Ref: SSD-71687208

**Property Address: 618 – 624 Mowbray Road West and 25 – 29 Mindarie Street Lane Cove North (Lots 17-20 and 64-66 in DP 35865)****Mowbray Road Lane Cove North Affordable Housing SSD-71687208**

Thank you for the opportunity to comment as part of the EIS for the construction of a 5-storey RFB with 86 dwellings including 43 social housing dwellings and 43 affordable housing dwellings.

Lower Ground Floor Plan

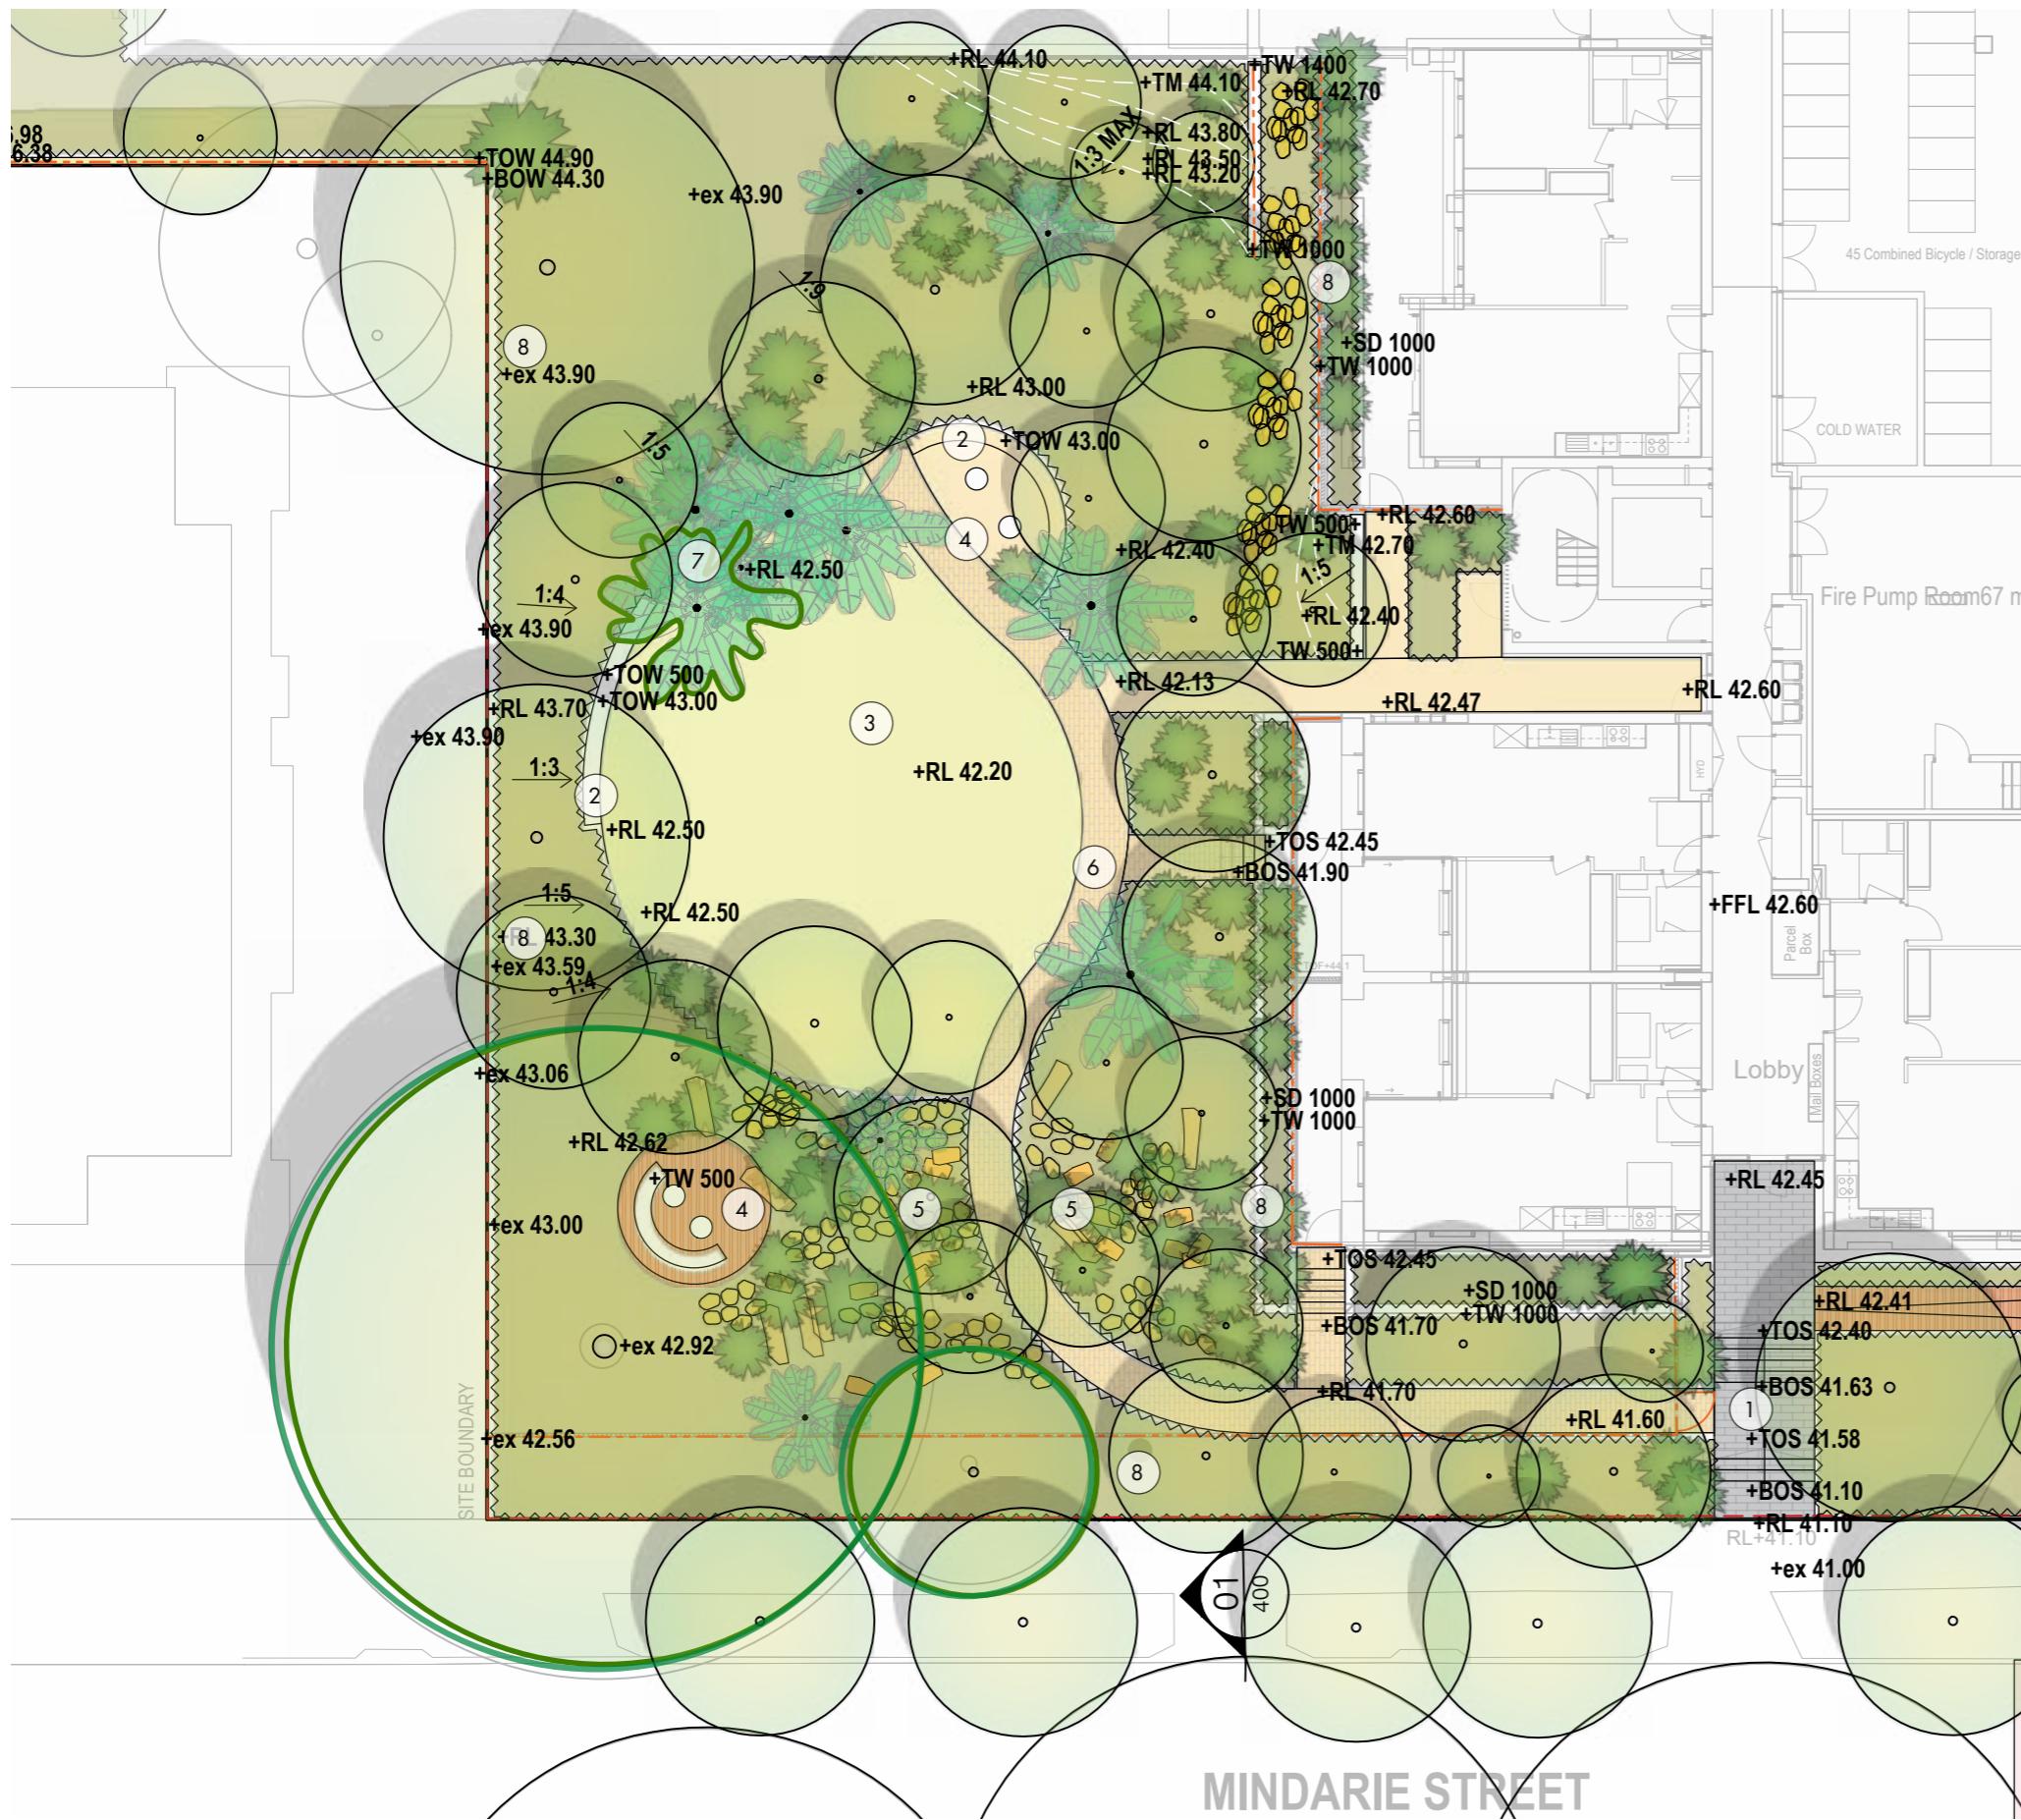
The site for the proposed development has 6 High Retention value trees and 10 Moderate Retention value trees for retention consideration. Trees #74, #75, & #76 are located on the opposite Council verge and T#55 is located on 31-39 Mindware Street. All these trees must be retained and avoiding any disturbance to their Tree Protection Avoided or managed to minimise impact.

Trees #53 and #56 are also High Retention value trees and further consideration should be given to their retention as they are a major part of the canopy on site and form part of the Sydney Blue Gum High Forest (STIF) endangered forest community in the area as well as being visible from quite a distance:

Communal Rooftop Plan

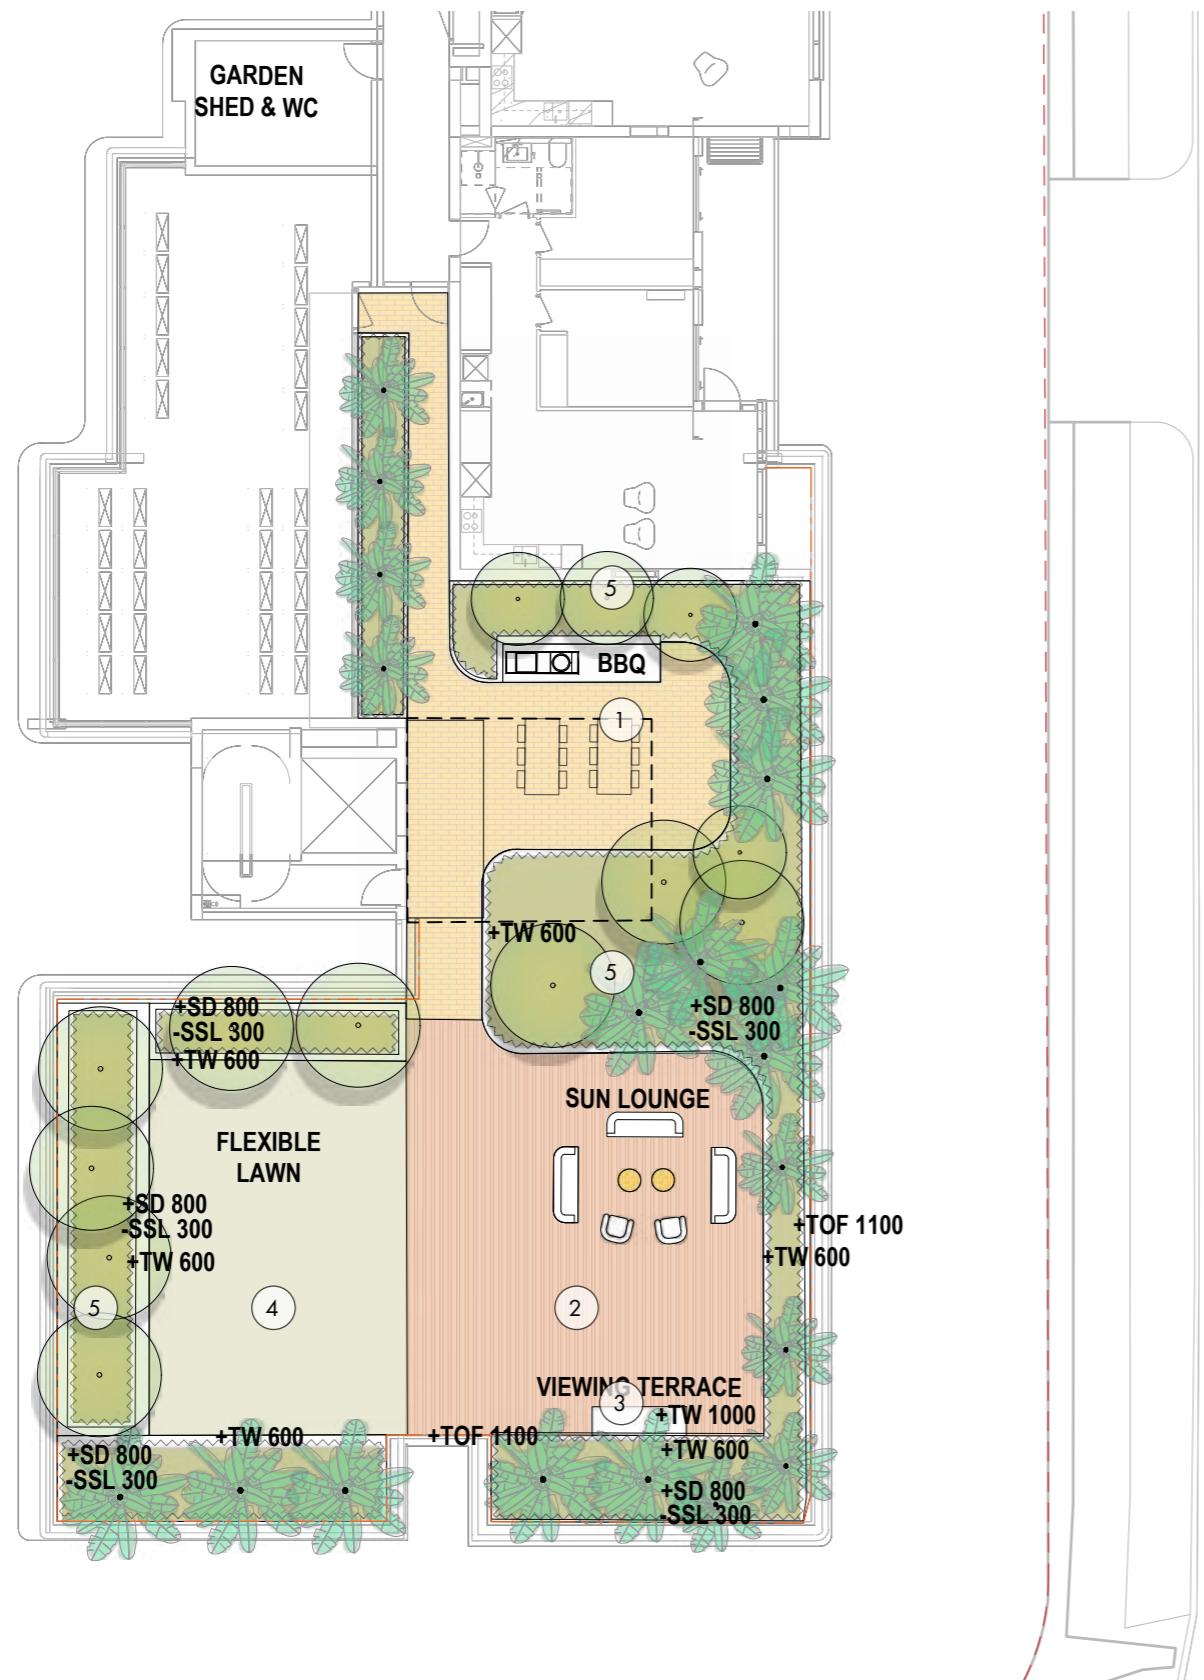
A revised landscape documentation package shall be submitted to Council's Landscape Architect for assessment that is fully compliant with the Apartment Design Guide 2015 standards for minimum soil depths for plants (table below) shall be submitted to Council's Landscape Architect before issue of Construction Certificate, specifically the planter boxes on drawing LD-DA110 Revision 1 – Level 03 Rooftop as some of the raised planter boxes do not provide adequate soil volume as prescribed.
